Consultation Response from: KC Environmental Health (Pollution & Noise Control)
2024/92454 - Land to North and South of, Crossley Lane, Dalton, Huddersfield, HD5 0QP

Discharge of details reserved by conditions 5 (access highway works), 6 (traffic calming measures), 8 (construction traffic), 9 (Phase II Intrusive Site Investigation Report), 10 (Remediation Strategy) and 14 (landscape) of previous outline permission 2015/90430 for erection of residential development comprising (Use Class C3) and incorporating associated new access (to Crossley Lane and Cold Royd Lane) and associated works

Date Responded:
2nd December 2024
Responding Officer:
NH
Responding Ref:
WK/202436285
Conditions 9 and 10 – Phase 2 Investigation and Remediation Strategy

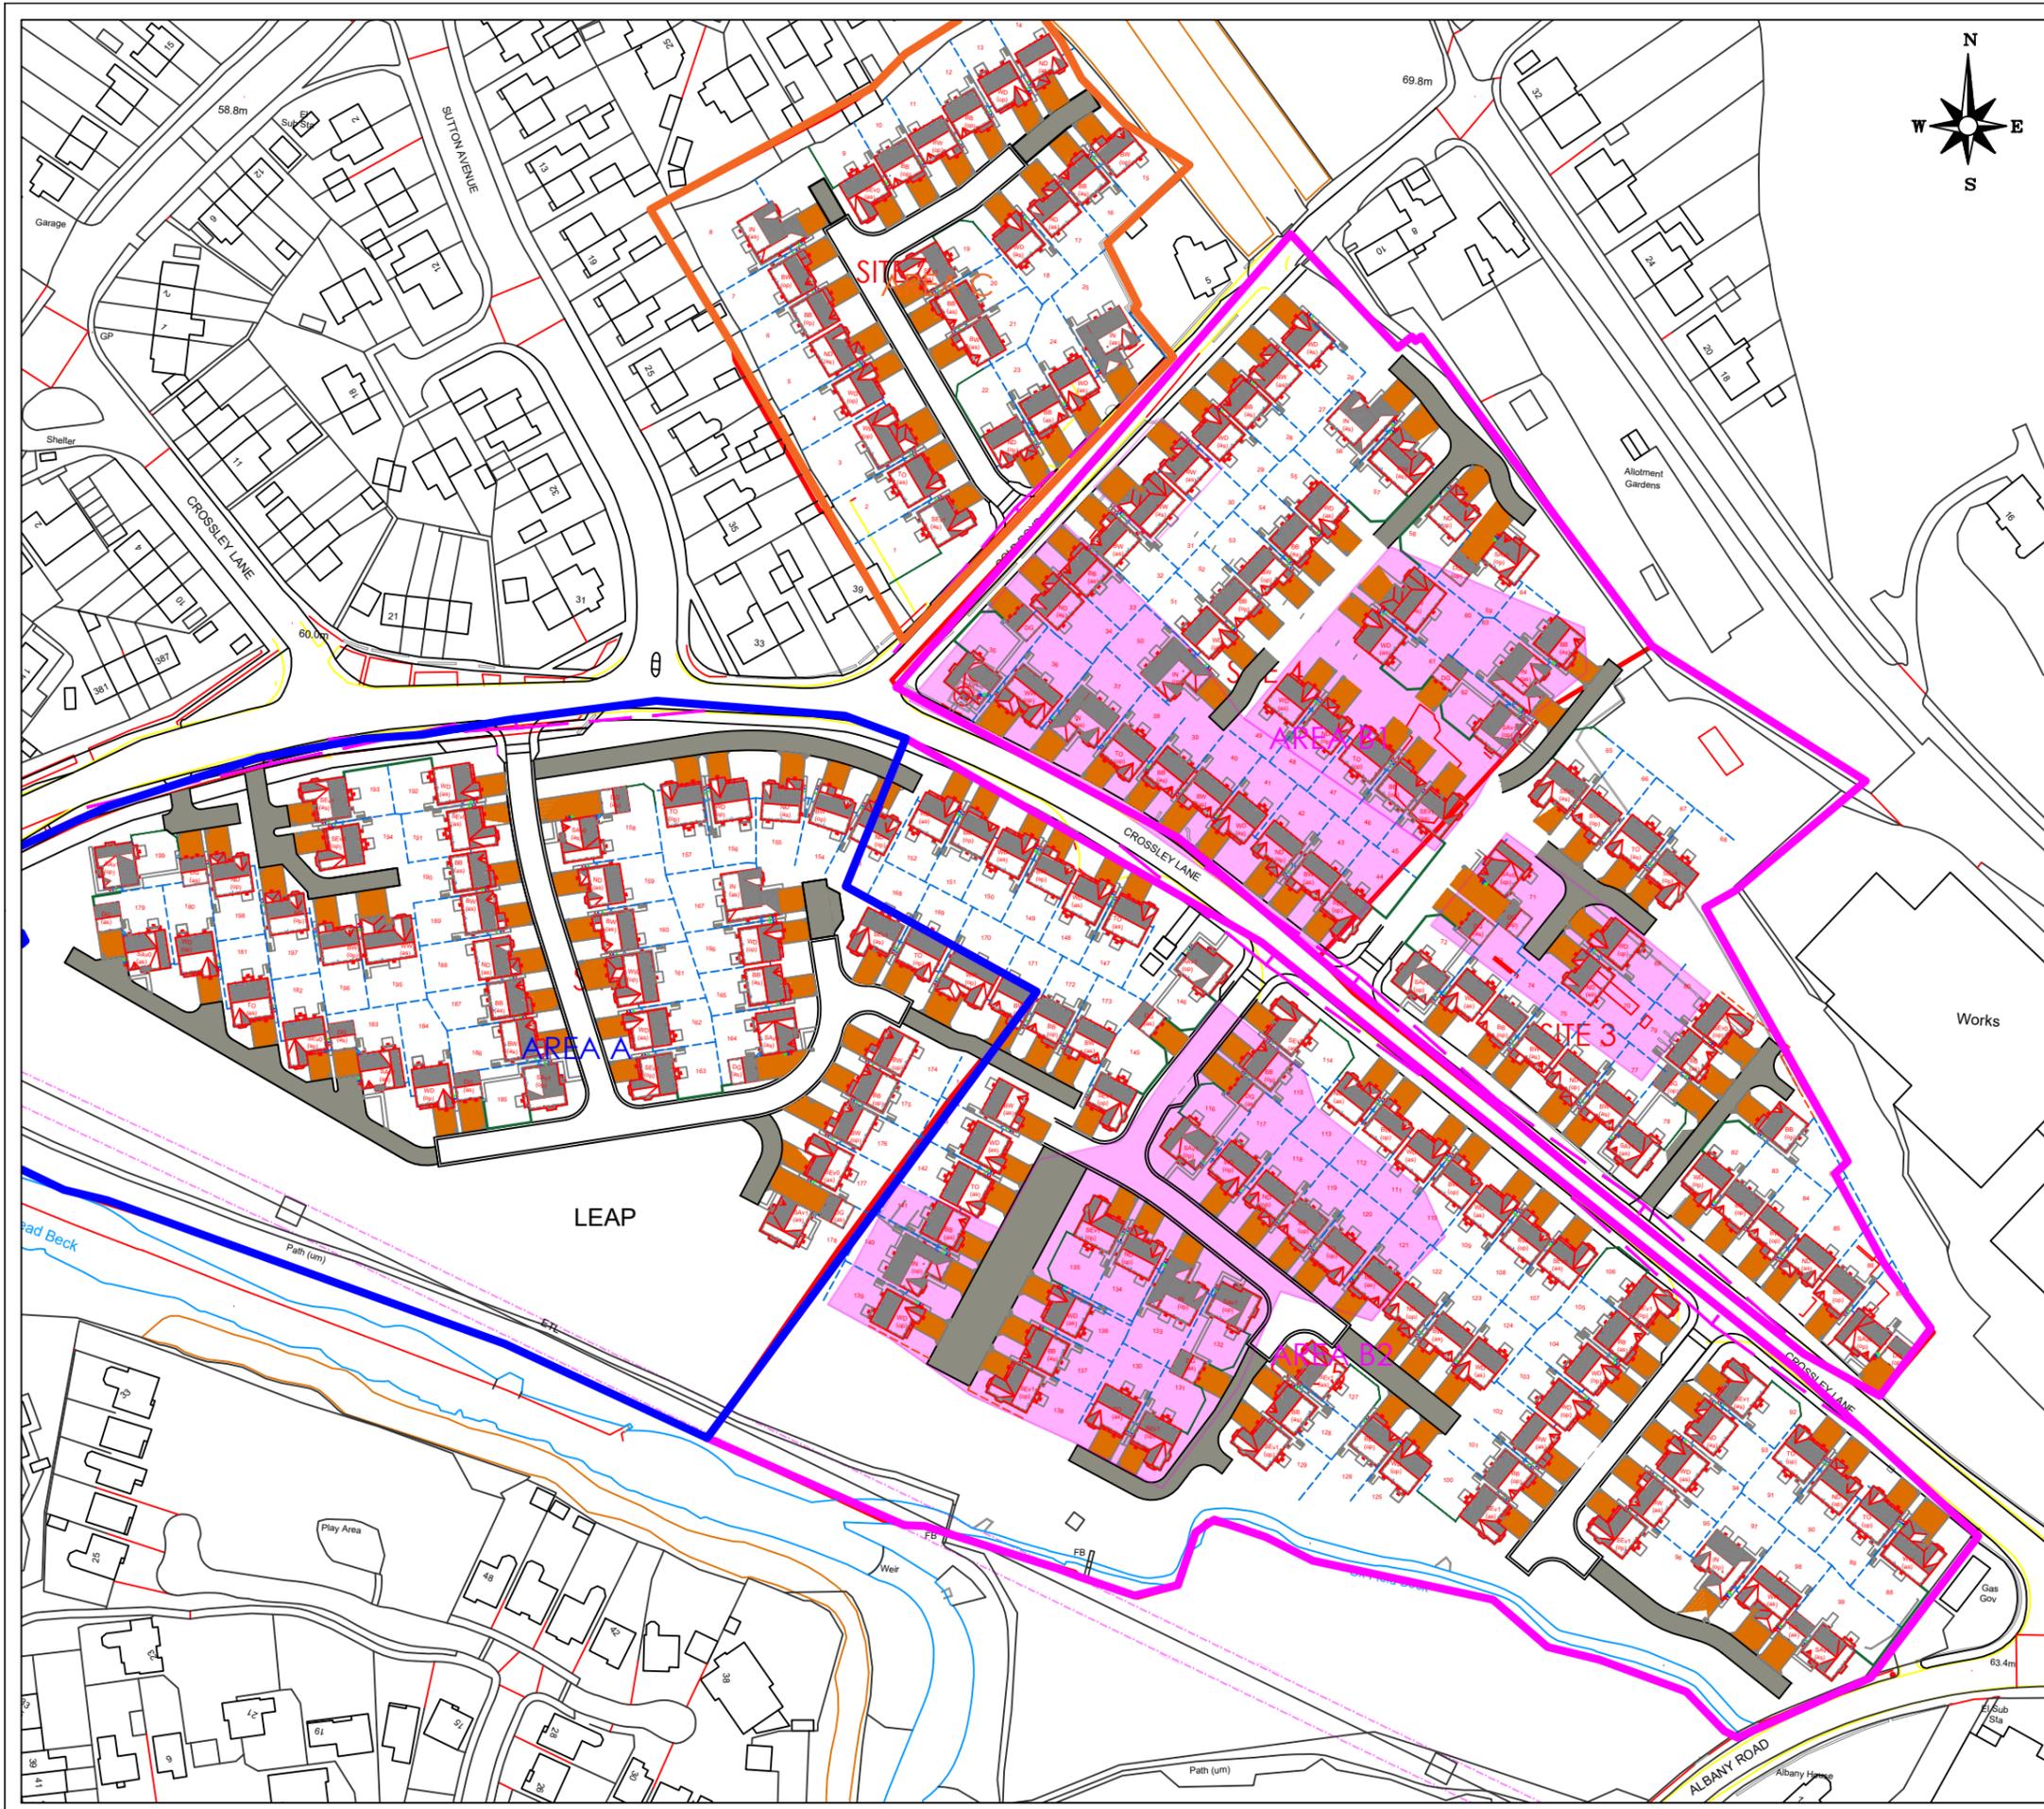
- In addition, Lithos recommended 30 additional gas monitoring locations, following ARP's investigation, but the documents suggest that fewer locations were actually monitored in Lithos's investigation. Given the incomplete information received and to aid our understanding of the site, we request a full explanation of the chosen sampling methodology, including details on the selection of sampling locations, monitoring locations, and the testing suites used.
